DECISION DELEGATED TO HEAD OF PLANNING

Application No: H23-0766-24 **Applicant:** Mr D Ford

Proposal: Proposed conversion of existing agricultural building to form 2 new dwellings

Location: Carter'S Farm Oxcroft Bank Shepeau Stow

Visibility Splay Plan

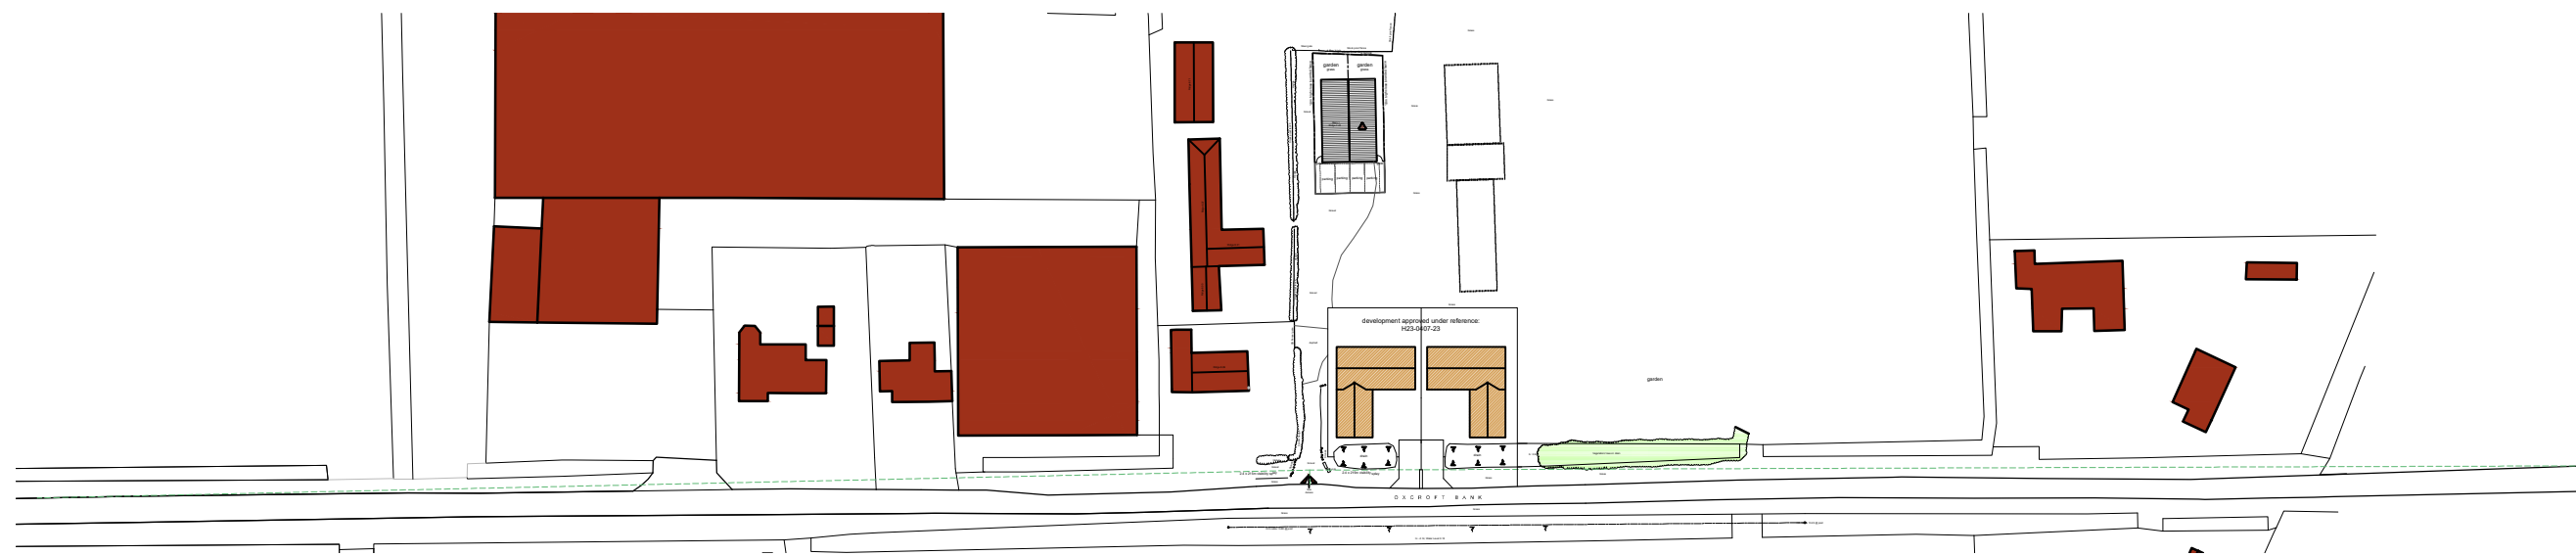
Highways and SUDS Support: The access width should be detailed- it should be a minimum of 4.1m for the first 10m and 3.7m thereafter. The access is to be upgraded to Lincolnshire County Council specification.

The proposed access to the site is from Oxcroft Bank to the west of the site. There is an existing access road to the site which would continue to be used. Lincolnshire County Council's highways and sustainable drainage team have set out that the access width should be detailed and that it should be a minimum width of 4.1m for the first 10m and 3.7m thereafter. The access is not as wide as recommended in places. For example, it is approximately 3.4m wide in some places. Notwithstanding this, the proposal is only for two dwellings which reduces the potential for more than one car needing the use the access at one time. It is therefore not considered that the access would pose an unacceptable risk in terms of highway safety. There is sufficient room for parking and turning within the site.
